Rezoning Transportation Analysis

Petition Number: 2025-104

Date	Description
9-24-25	First Review (CM)
10-23-25	Second Review (CM)

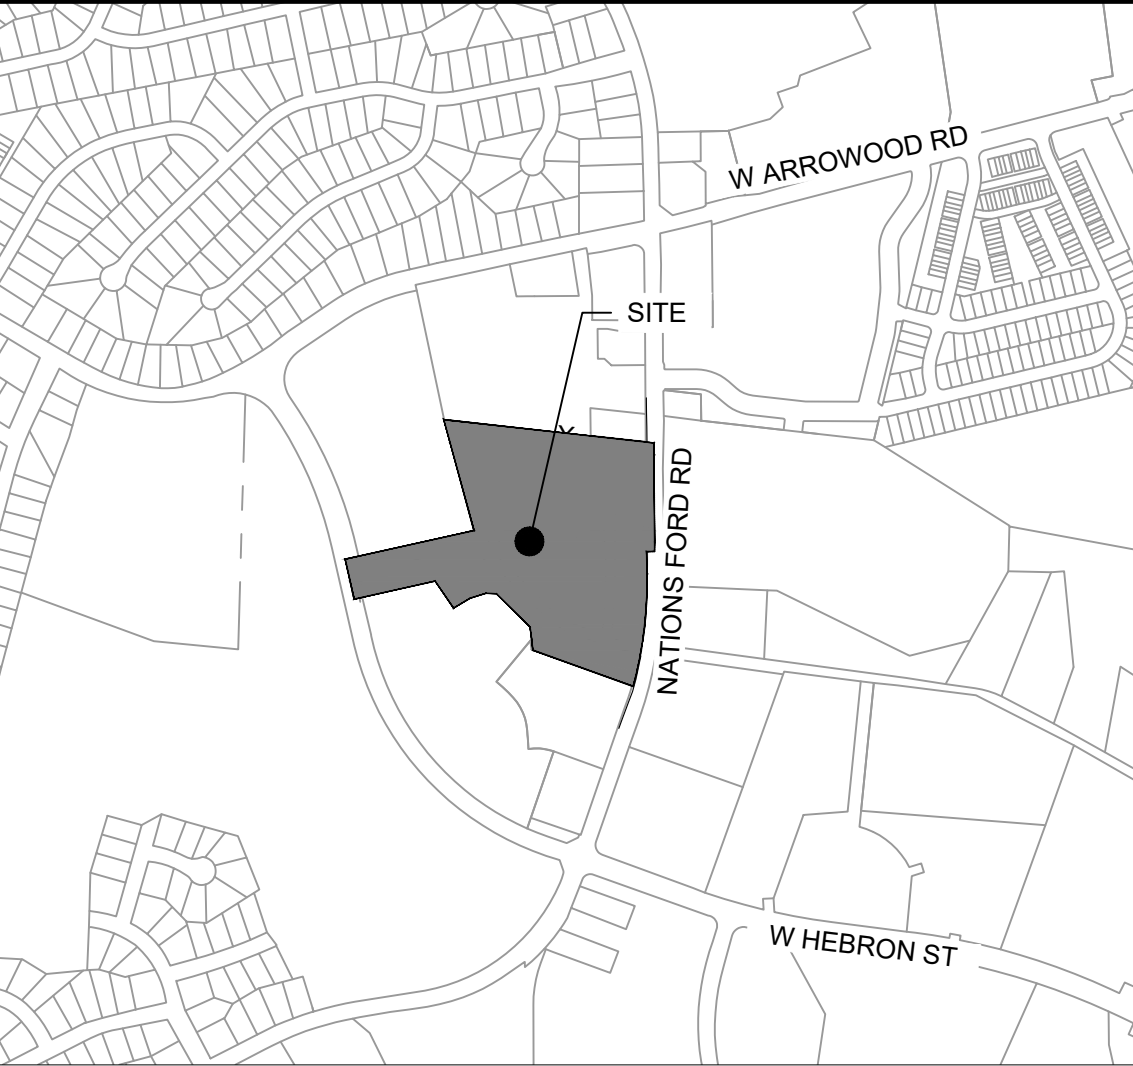
Label and dimension the curb and gutter from the centerline for each road on the site plan.

4. Revise site plan and conditional note(s) to commit to construct bicycle facilities by locating the curb and gutter 27' from the center line along Nations Ford Road in accordance with the council-adopted Charlotte Streets Map. Site plan to callout and dimension bicycle infrastructure and add a conditional note to committing to this improvement.

Clarifying Comment 10.23.25: Revise site plan by showing and labeling the bike facilities or provide the Charlotte Streets Map street label for Nations Ford Road (2+ Avenue with Buffered/Separated Bike Lanes).

6. Revise site plan and conditional note(s) to label Road A, B, and C as public roads, private roads, or private alleys. Add road labels for all roads to site plan. Add conditional note(s) identifying each roadway.

Clarifying Comment 10.23.25: Revise site plan and conditional note(s) to label Road B and Road C as public or private roads. Add road labels for all roads to site plan. Add conditional note(s) identifying each roadway.

7. Revise site plan to show Road A has adequate intersection separation from Nations Ford Road per CLDSM guidelines.

Clarifying Comment 10.23.25: Revise site plan and dimension to show minimum 200 feet separation between Road A and Nations Ford Road per CLDSM requirement for intersection separation along collector roadway.

8. Revise site plan to adjust stub location of Road A to the west to stub into the larger western parcel in coordination with Subdivision.

Clarifying Comment 10.23.25: In coordination with subdivision shift stub road to larger parcel for better chance at future connection.

9. **Outstanding Comment 10.23.25:** Revise site plan and conditional note(s) to provide a streets stub and right-of-way in accordance with the original Old Hebron Road alignment per Charlotte Streetsmap. The alignment of the proposed Old Hebron Road may need to be modified to accommodate the roadway stub and the original alignment. Final design to be coordinated with CDOT during permitting. Add a conditional note committing to this improvement.
